Our Case Number: ACP-324568-26

Re: Proposed Development of the Barnesmore Gap Greenway Project
County Donegal

Re: Donegal County Council (Barnesmore Gap Greenway Project) Compulsory Purchase Order 2026

FORMAL OBJECTION TO THE COMPULSORY PURCHASE ORDER

Drawing file: Chapter 04 Description of the Proposed Development / 60701883-ACM-HGN-SW_ZZ_ZZ_ZZ-DR-HG-0132 Eske Bridge.pdf

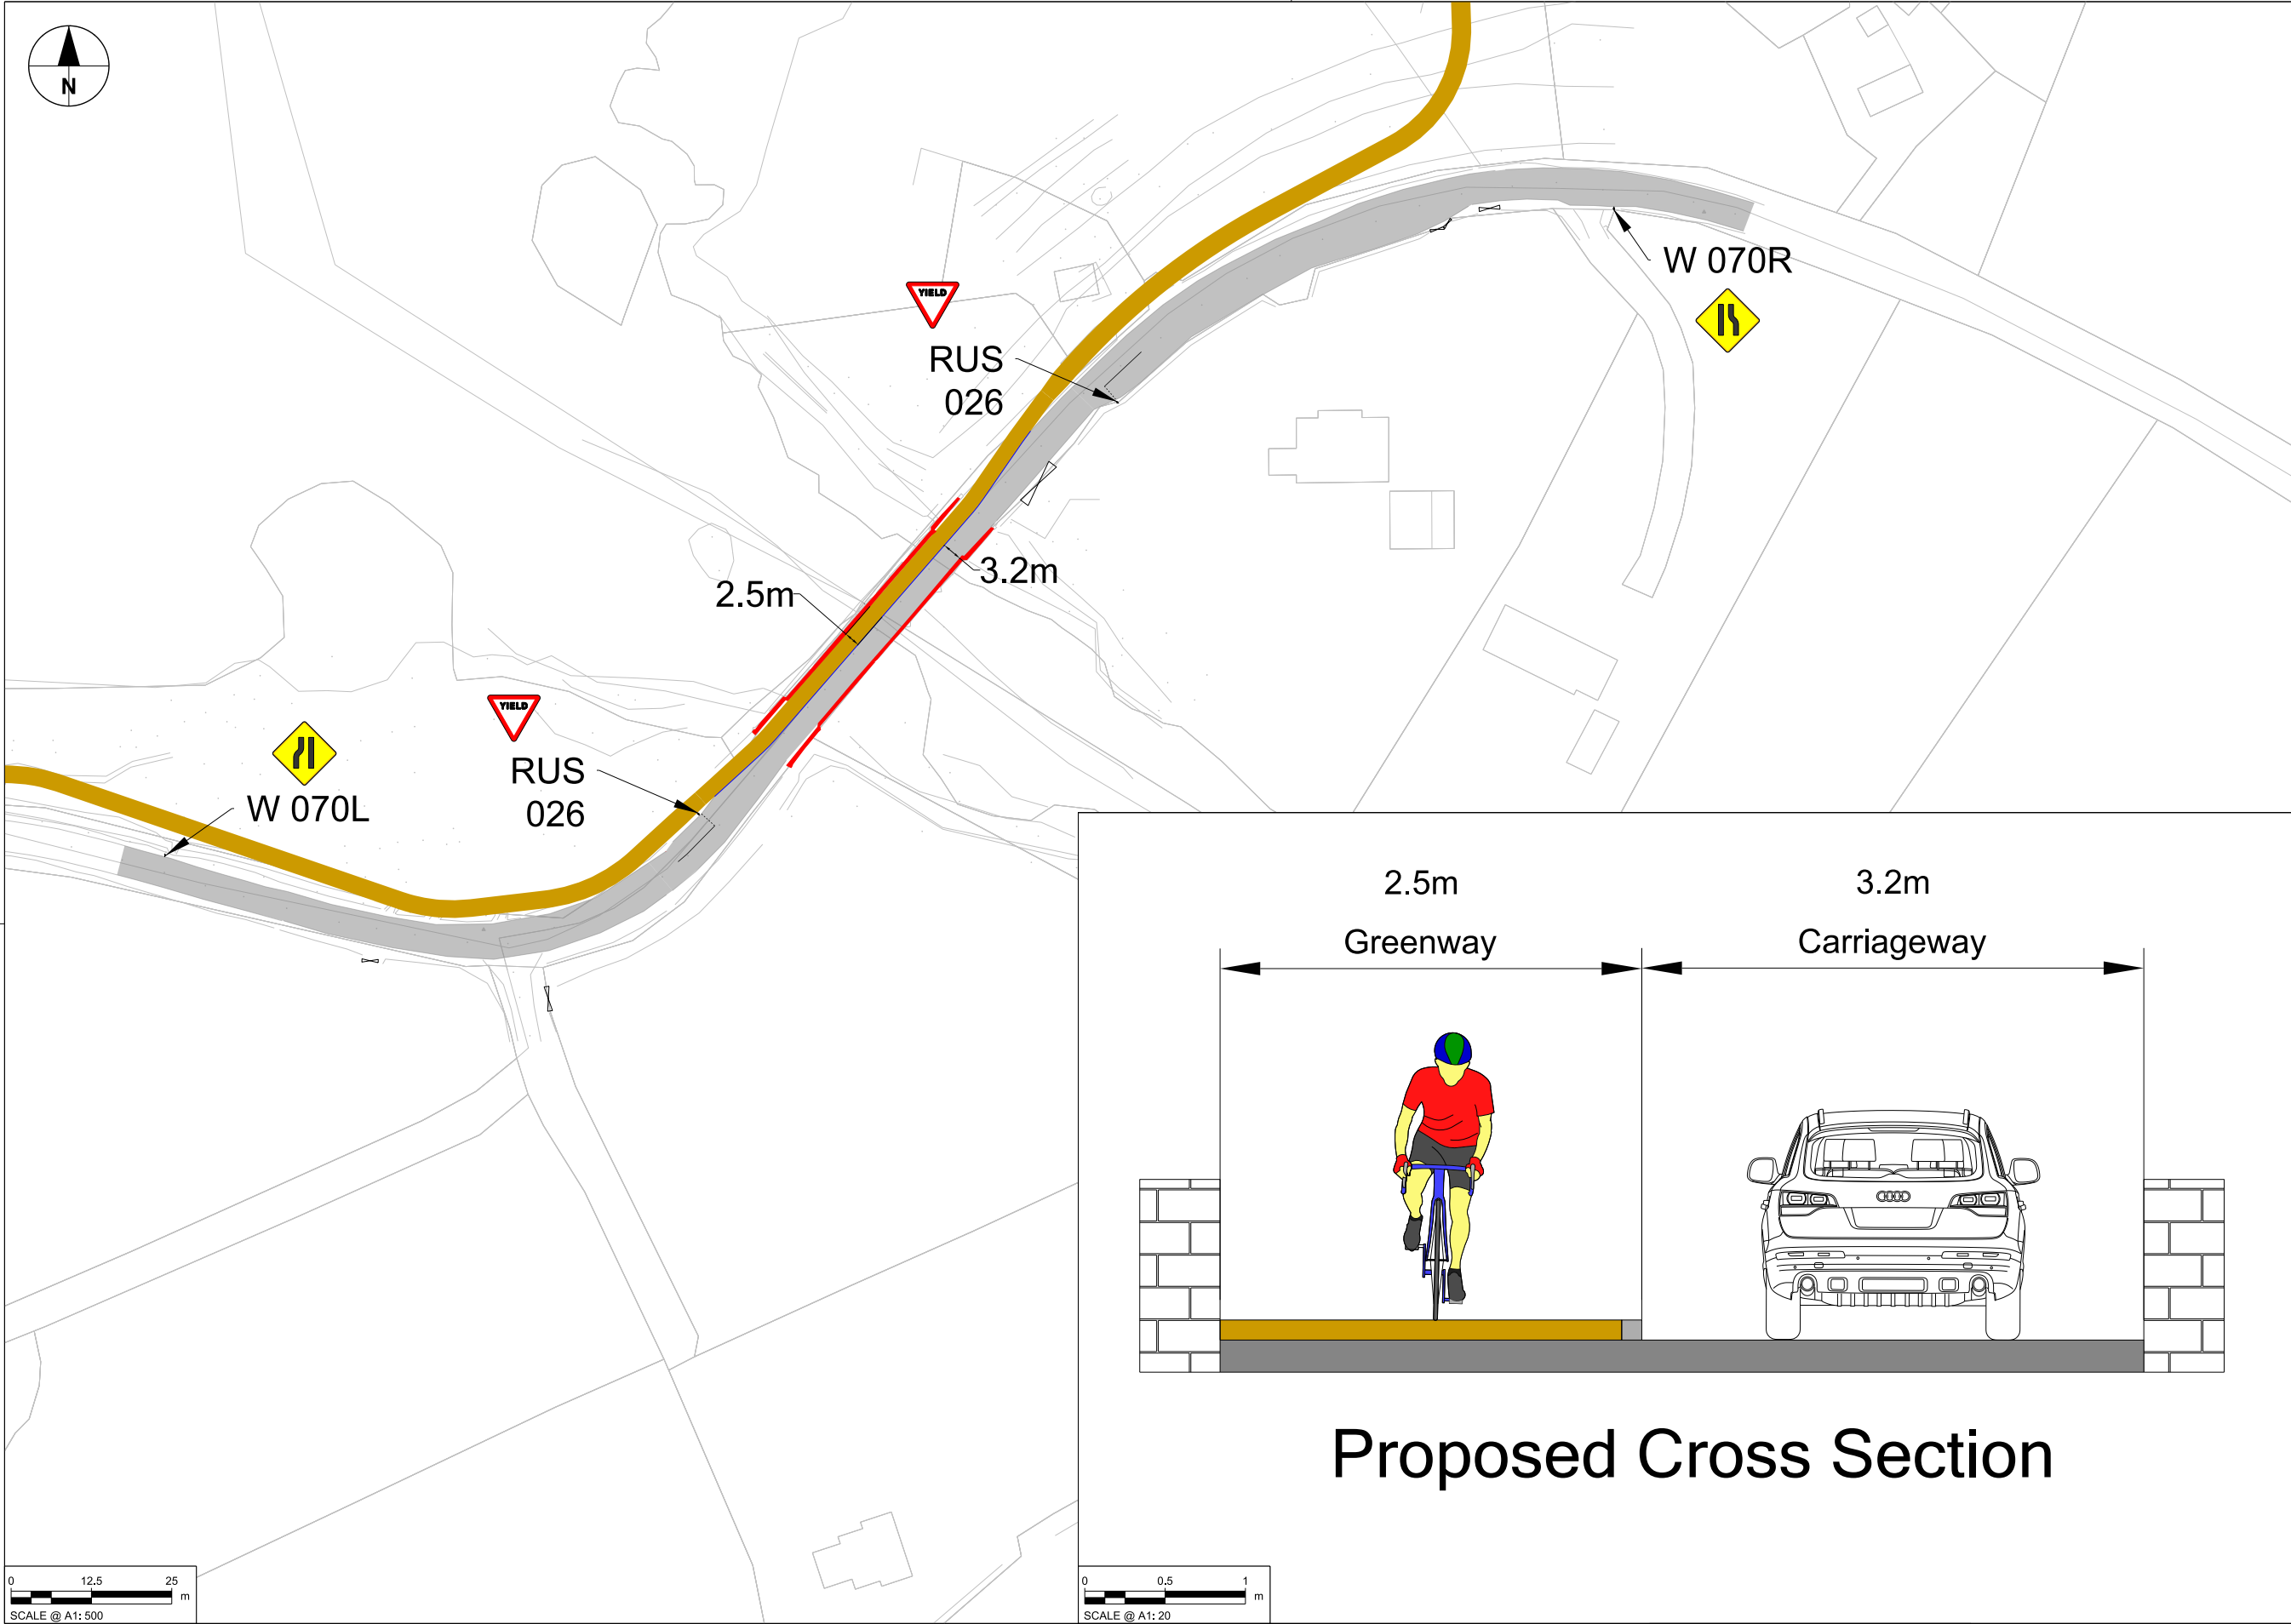
The proposed changes associated with the Lough Eske bridge and road arrangements give rise to serious concerns regarding our continued ability to use this access safely and practically.

We strongly object to the proposed reduction of the existing two-lane Lough Eske river bridge to a single lane for vehicular traffic insofar as it affects our property and our ability to safely access and use our home.

The existing bridge is already constrained and, in our experience, is barely capable of accommodating two cars passing.

Reducing the bridge to a single lane will inevitably introduce additional traffic management and queuing.

The proposed single-lane arrangement creates a foreseeable risk of traffic being stopped and queued in front of our property.
